Re: Haberman (BL-10-00023)

After conducting a review of the above named project, I have the following comments:

BL-10-00023 Haberman

Proposed Boundary

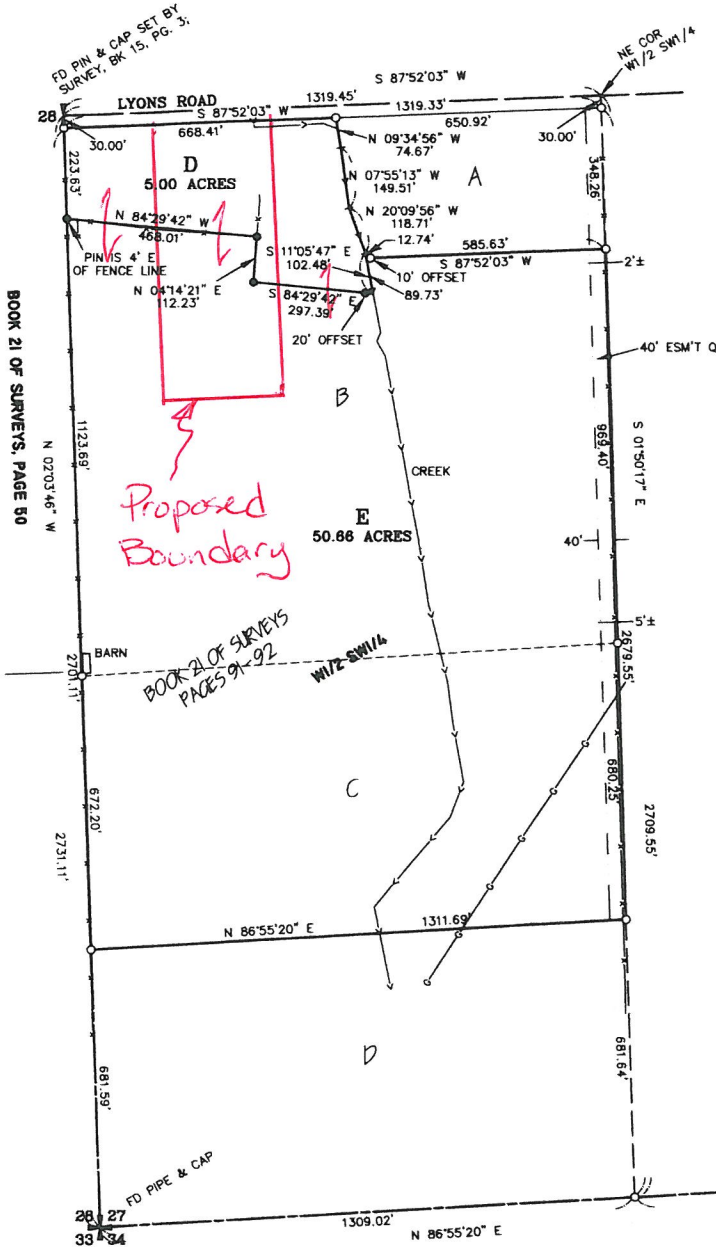
- Ensure that boundary line adjustments do not infringe upon existing structures, to include propane tanks, etc.
- All future development must comply with the International Fire Code.

I am curious where the drainfield and well is on this one too.
